**A57 Link Roads**

**9.72 Addendum to the Statement of  
Common Ground with High Peak Borough  
Council**

- 1.1.1. This document provides an update on the ongoing dialogue with High Peak Borough Council in relation to Air Quality matters. The document has been produced in response to the Issue Specific Hearing 3 held on the 5<sup>th</sup> of April 2022 in lieu of a full update to the Statement of Common Ground with High Peak Borough Council (REP2-018).

- LEGEND**
- MODELLED QUALIFYING FEATURES AND PUBLIC ACCESS
  - DEFRA PCM LINKS COINCIDING WITH ROADS MEETING THE DMRB LA105 TRAFFIC SCREENING CRITERIA
  - ROADS MEETING DMRB LA105 TRAFFIC SCREENING CRITERIA

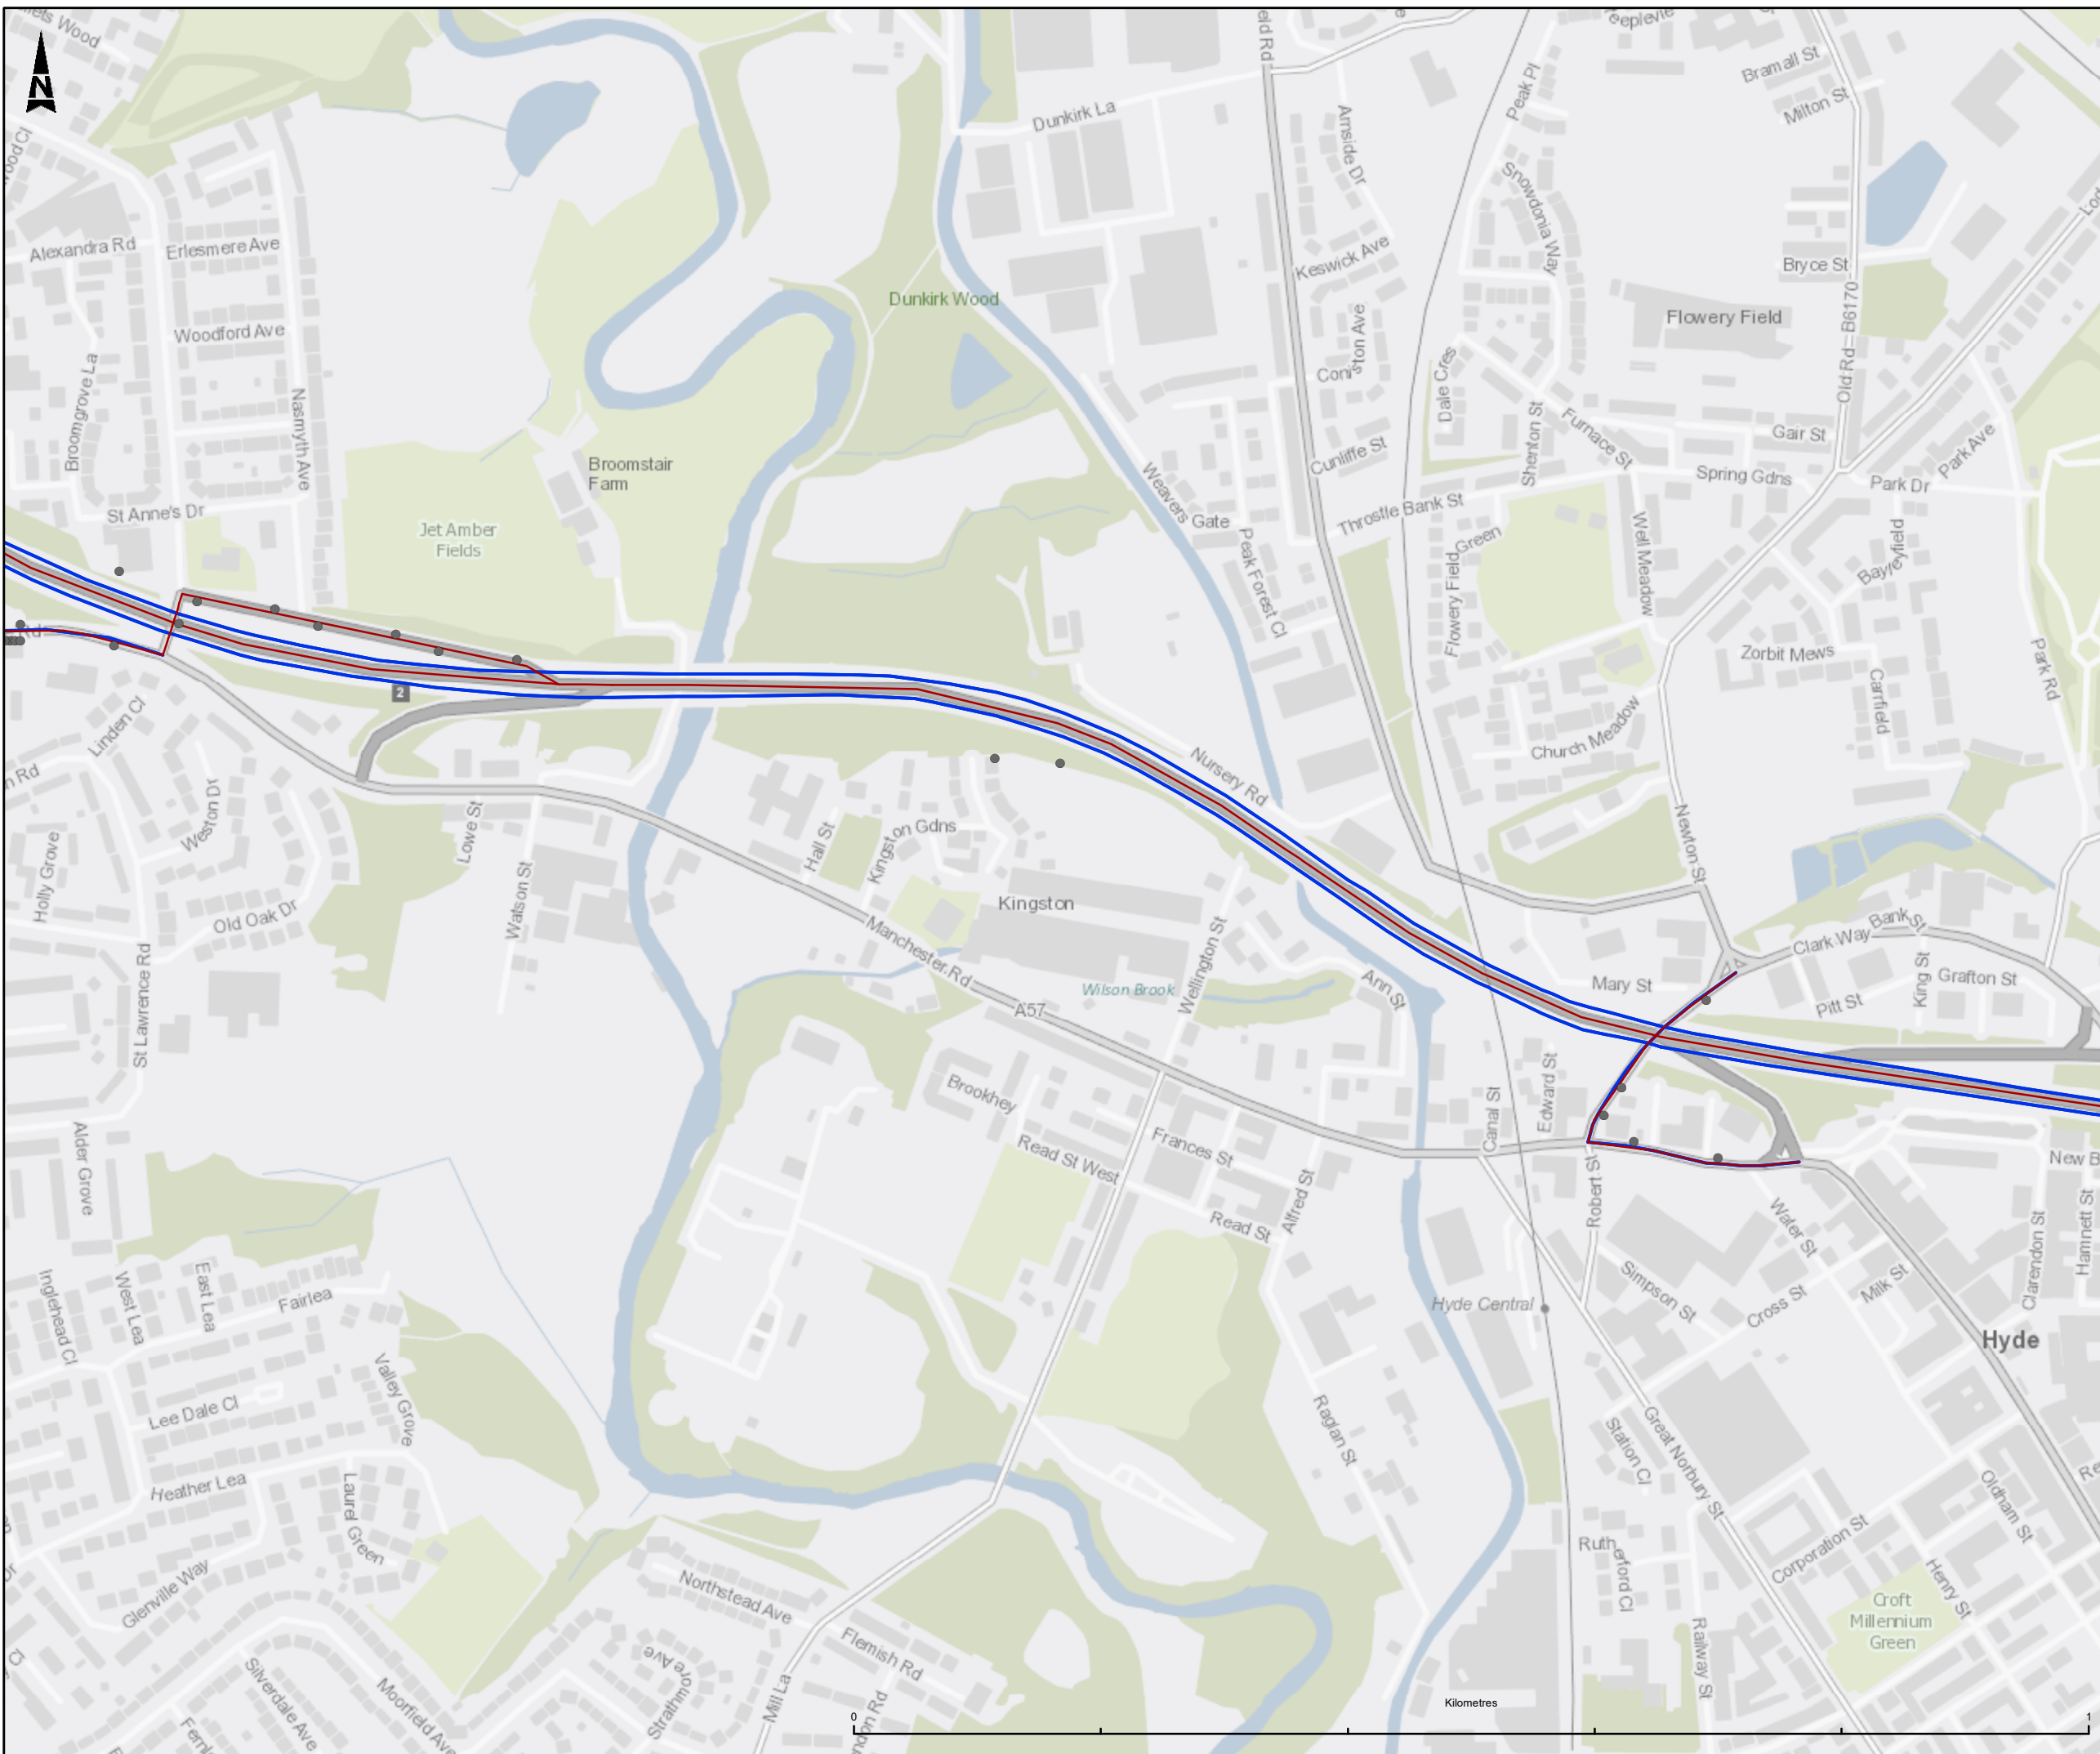
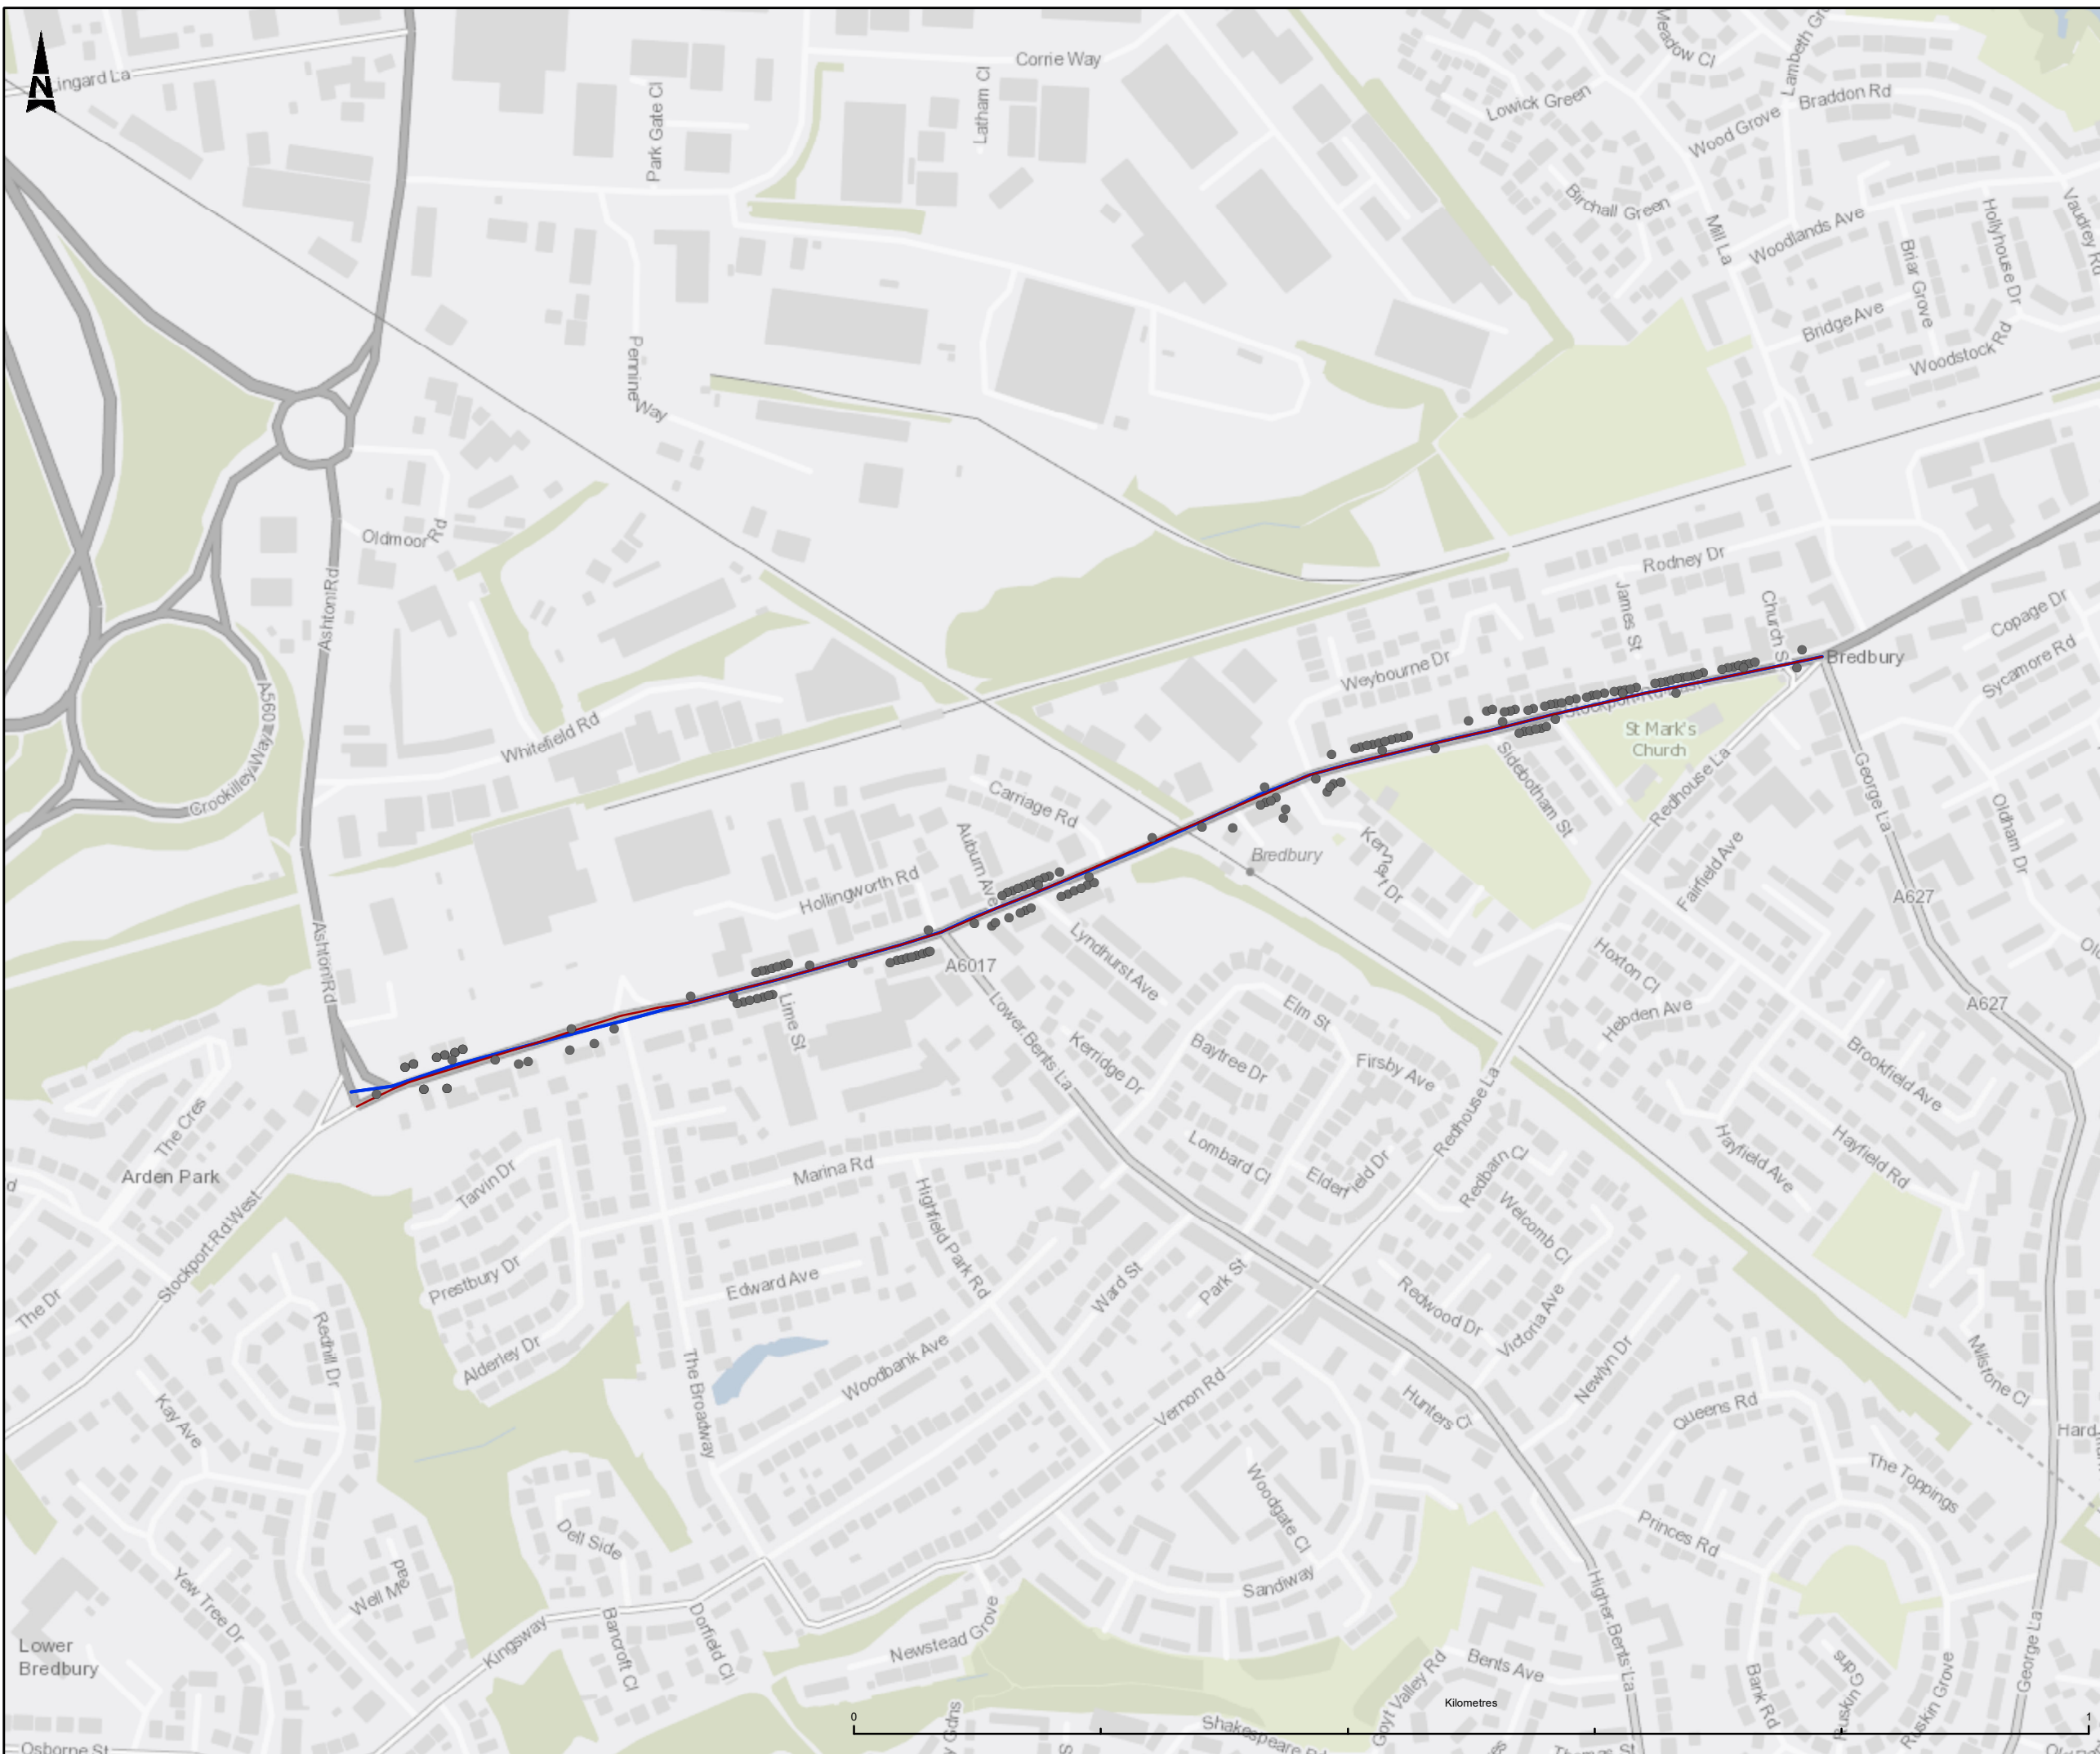
<b><u>Figure 5.4 Air Quality Compliance Risk Assessment – receptor labels</u></b>

HPBC Item	National Highways Position	HPBC Position	Status
<p><u>Item 8.38</u>            HPBC [REP4-011] asked for the A57 Brookfield qualifying features used in the NO2 compliance assessment to be labelled on ES Figure 5.4 [APP-080].</p>	<p>Given the number of qualifying features and public access receptors included in the compliance assessment it was not possible to practically label the qualifying features in ES Figure 5.4 (APP-080) however, an extract of ES Figure 5.4 zoomed in on the A57 Brookfield area with receptor ID labels for qualifying features and public access receptors adjacent to the A57 Brookfield is provided below this table.</p>	<p>Agreed  <u>Deadline 8 update (HPBC)</u>            It is noted that this response was supplied at deadline 7 by NH. Clarification of receptors did highlight that there were some relevant receptors in the Brookfield area that had not been included in general AQ assessment but had been included in the compliance assessment (see final row)</p>	<p>Closed</p>
